Our ref: XA/2025/100453/02-L01
Your ref: EN010153
Date: 22 December 2025

**ENVIRONMENT AGENCY RESPONSE TO DOCUMENTS SUBMITTED AT
DEADLINE 1.**

FRODSHAM SOLAR PROJECT, FRODSHAM MARSHES

**CROSSING CP22 PROPOSED SECTION B-B
ALTERNATE ARRANGEMENT
1:50**

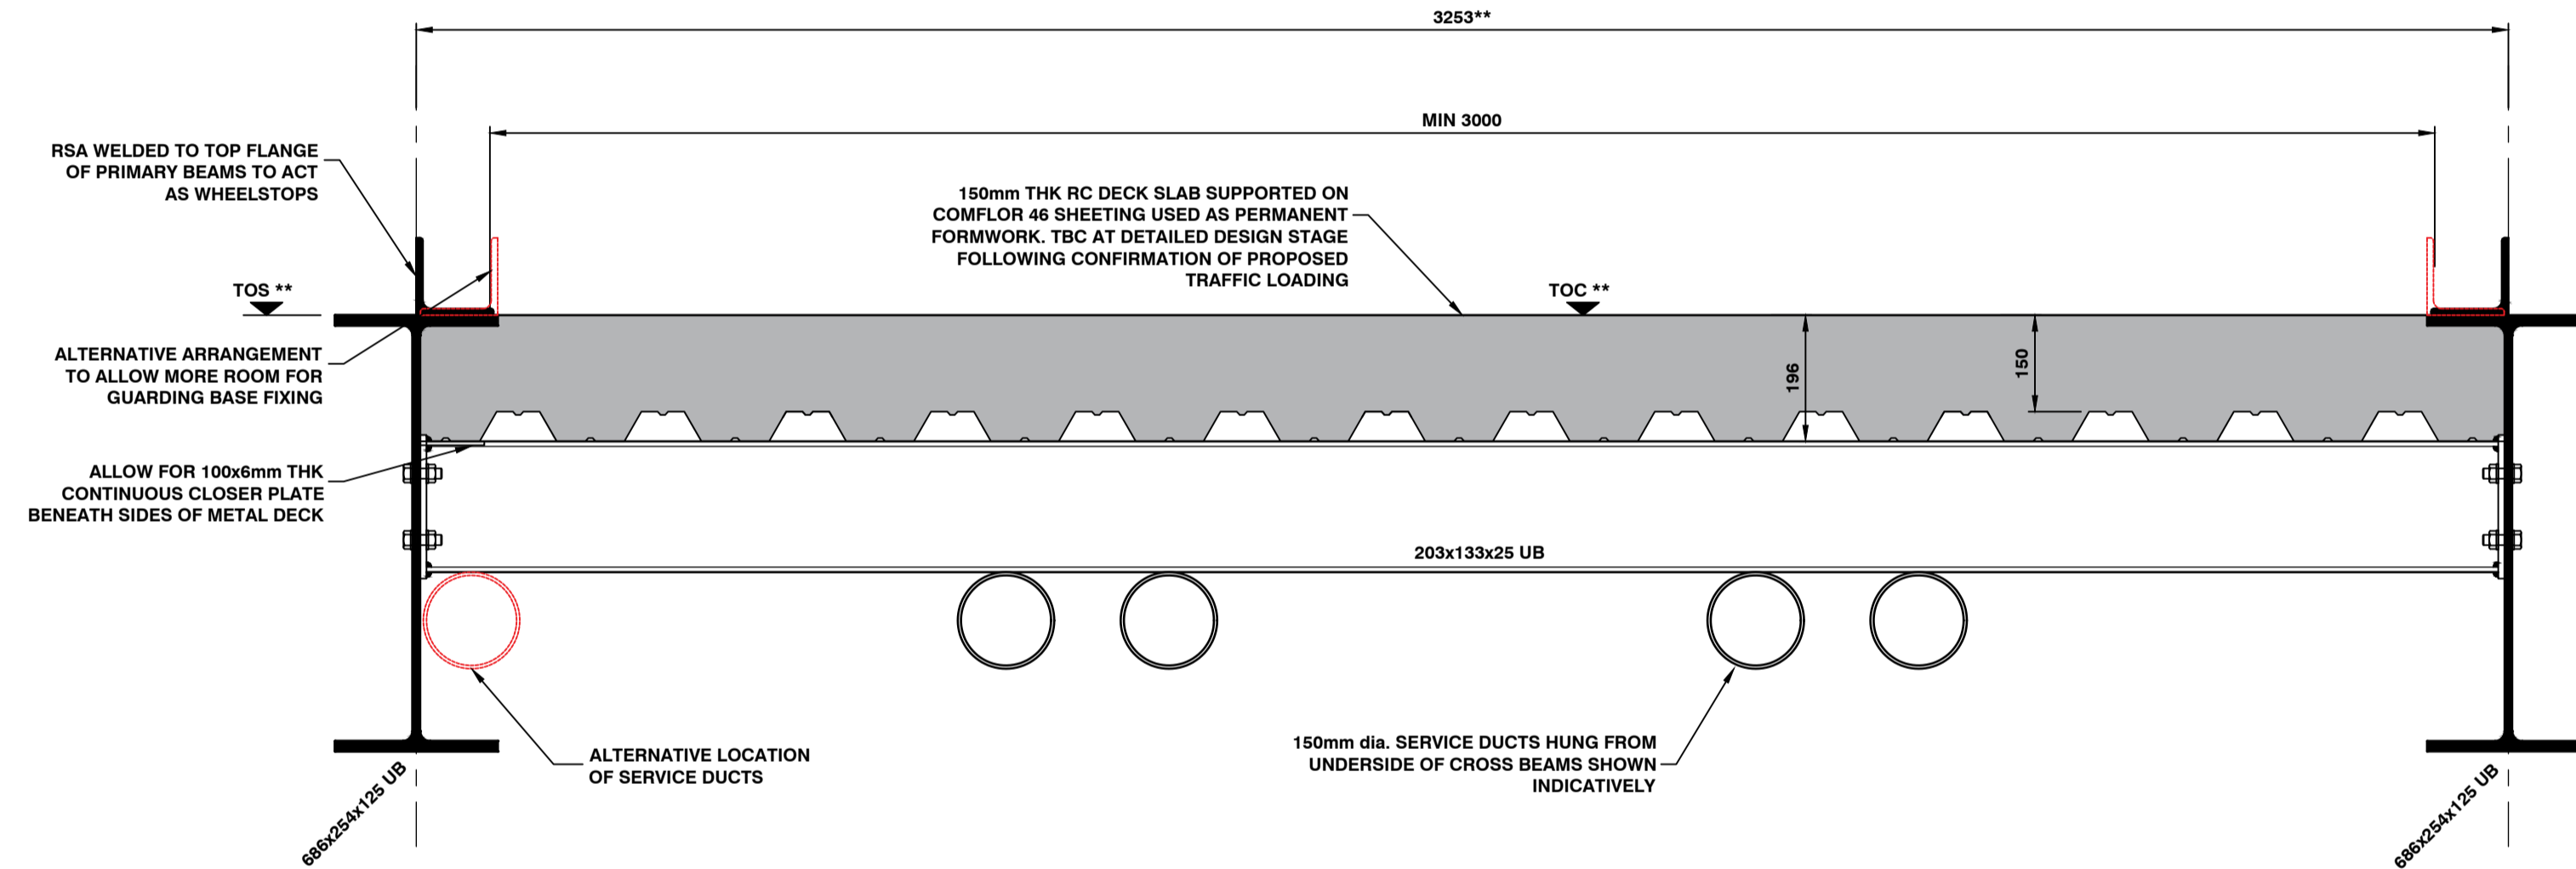
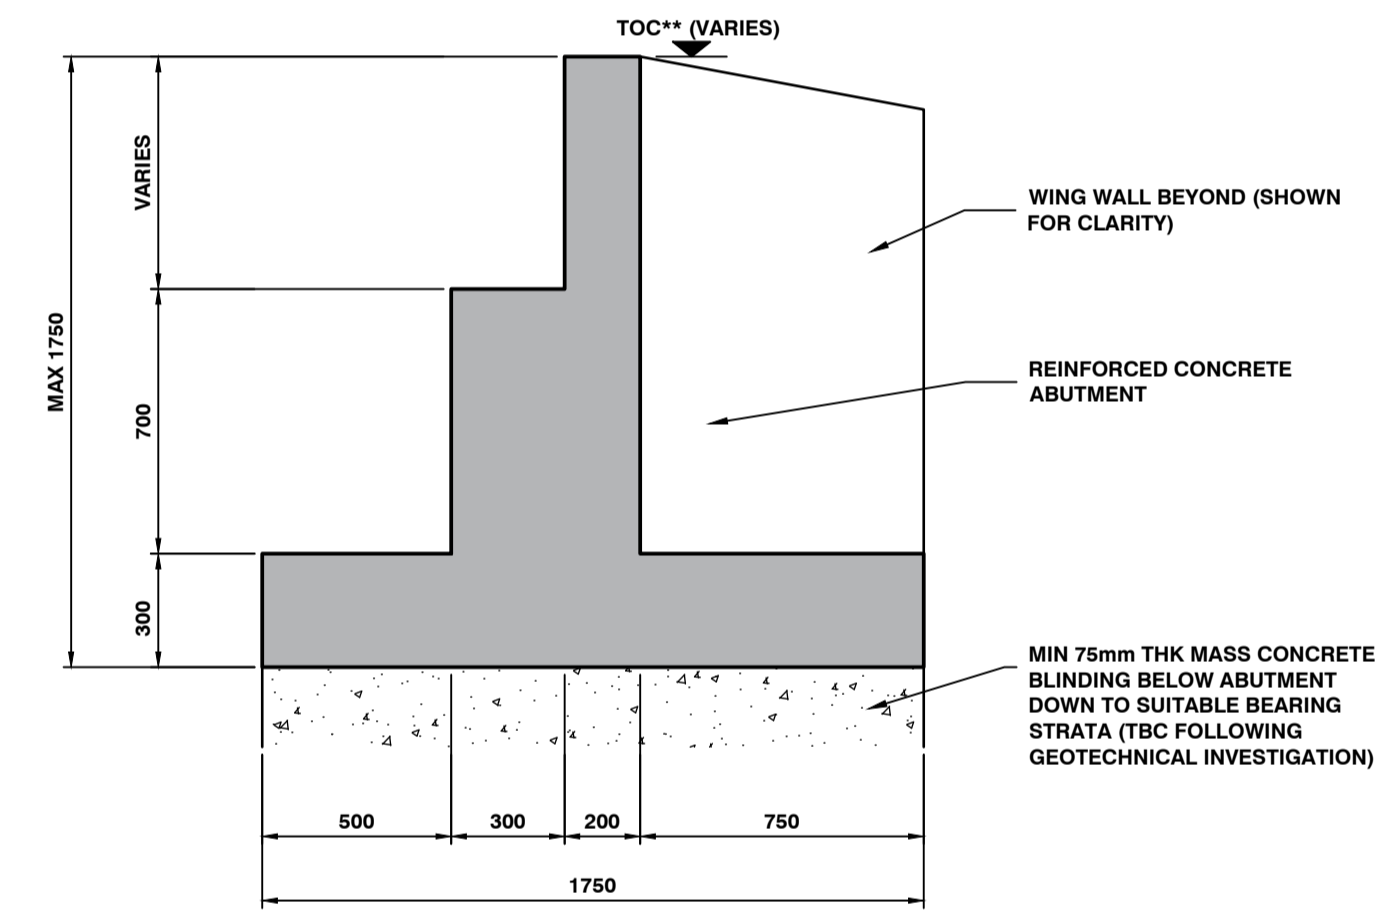
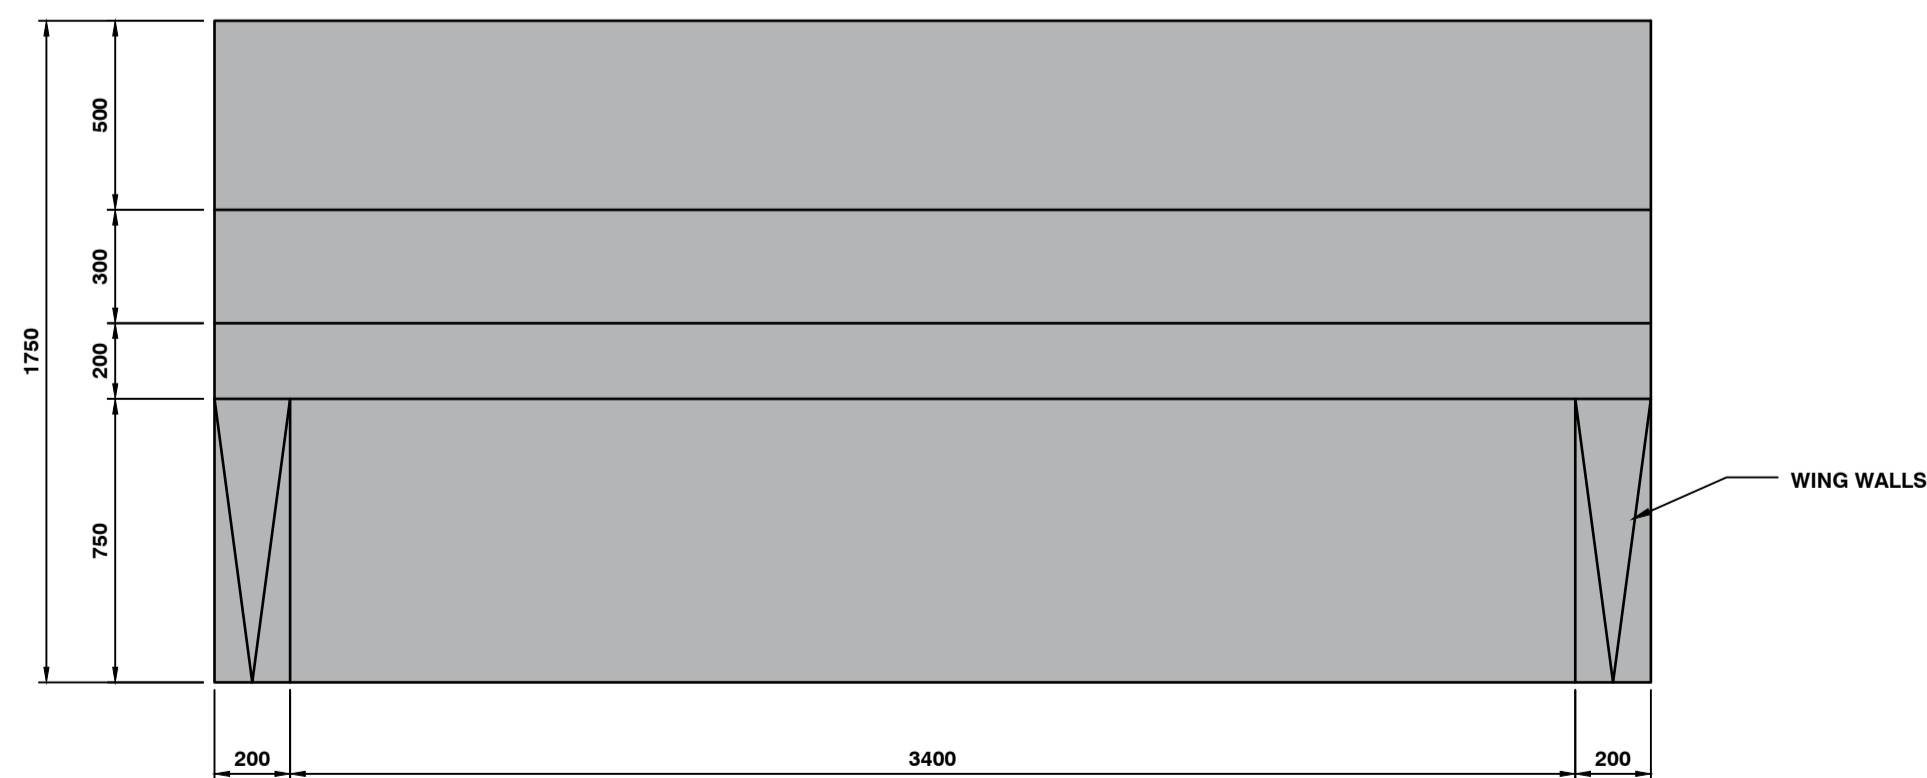
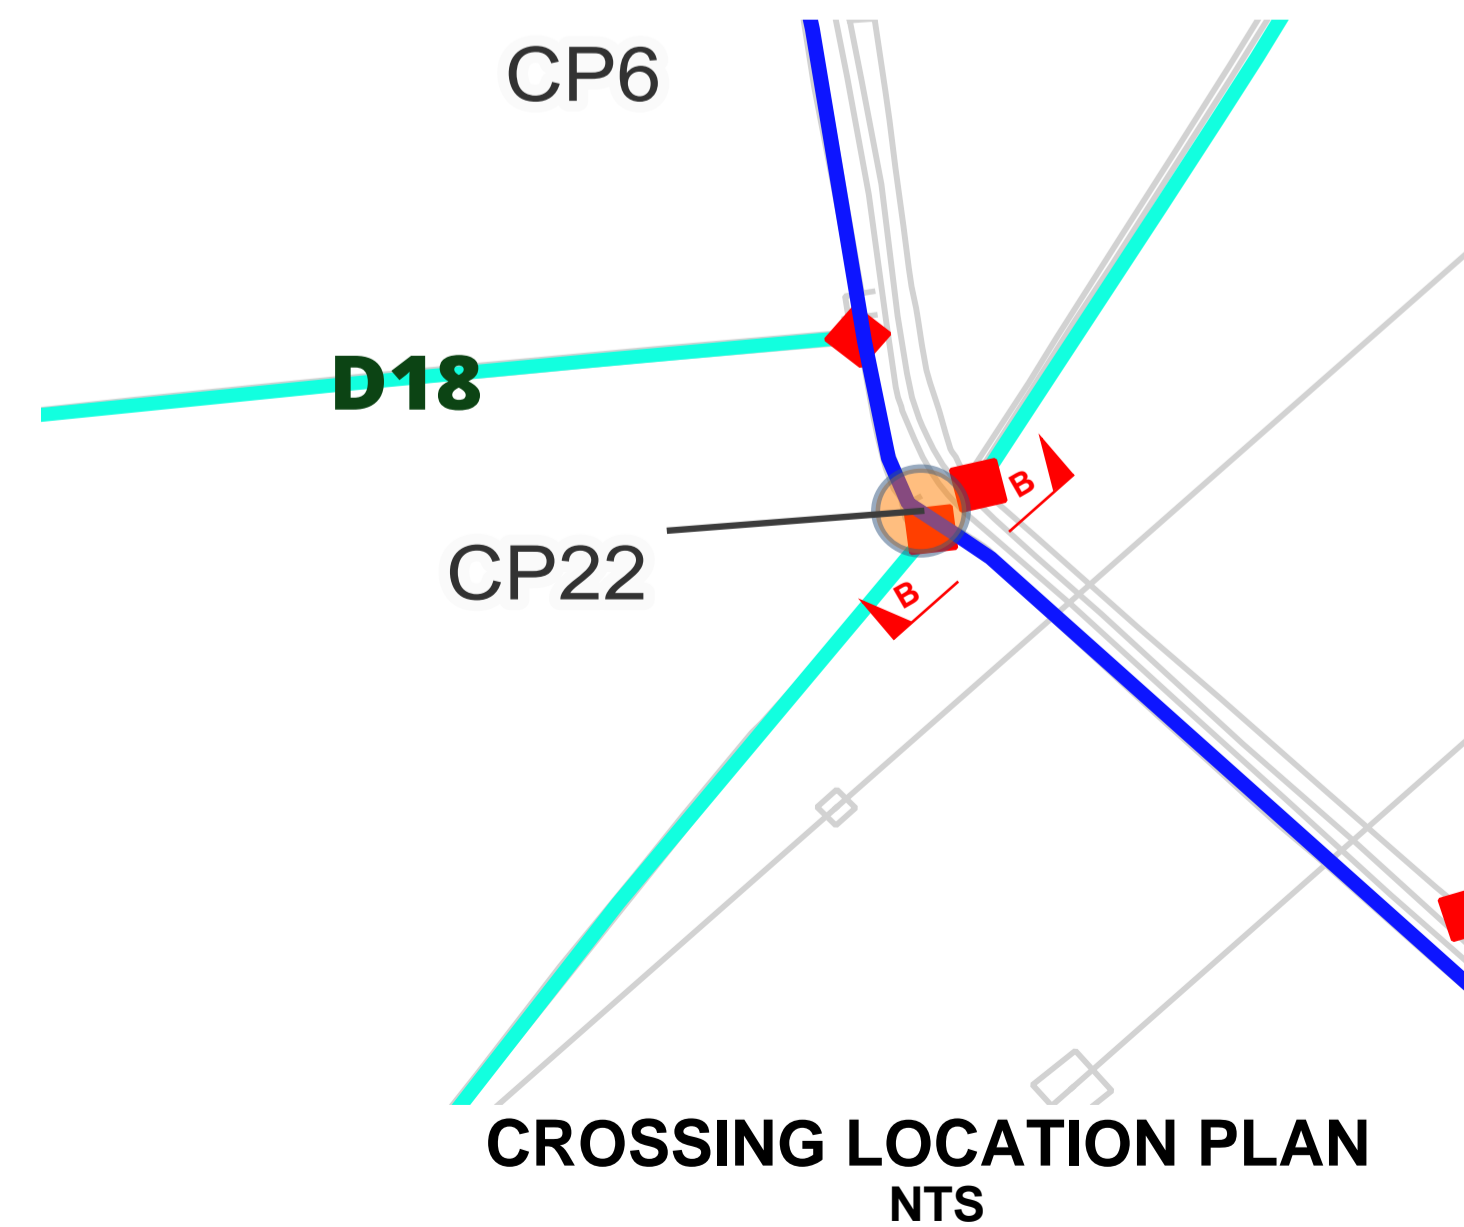
As the crossing proposed for CP22 would involve reprofiling of the embankment crest, with no plan to decommission and reinstate the embankment, we are concerned that it may increase flood risk beyond the lifetime of the development. We would only allow this proposed design if there's a commitment to removing the crossing, and reinstating the embankment crest, during the decommissioning phase. If the Applicant does not wish to remove the CP22, then we'd require a new design to be submitted that doesn't involve altering the embankment crest.

To resolve this issue, we require a commitment within the outline Decommissioning Environmental Management Plan (DEMP) that crossing CP17 shall be fully removed, including all superstructure and subterranean elements of the structure. For CP22, if the current design is preferred by the Applicant, then we'd require the same commitment as for CP17, with the additional detail of:

- reinstating the embankment crest to its original pre-development condition and profile, including soil structure, vegetation, and hydrological characteristics, unless otherwise agreed in writing with the Environment Agency.

Given that the design presented is the concrete option, and the Applicant complies with the above assumptions, then we consider the proposal acceptable in terms of operability during a flood event, in the context of debris impact and uplift for the watercourses which are to be crossed. However, we require the Applicant to confirm that the height of bridge decks will not fall below 5.3mAOD. This will ensure that assumptions in the report are correct.

- a commitment to removing cables embedded in crossings during decommissioning;
- confirmation of the height of the bridge decks.
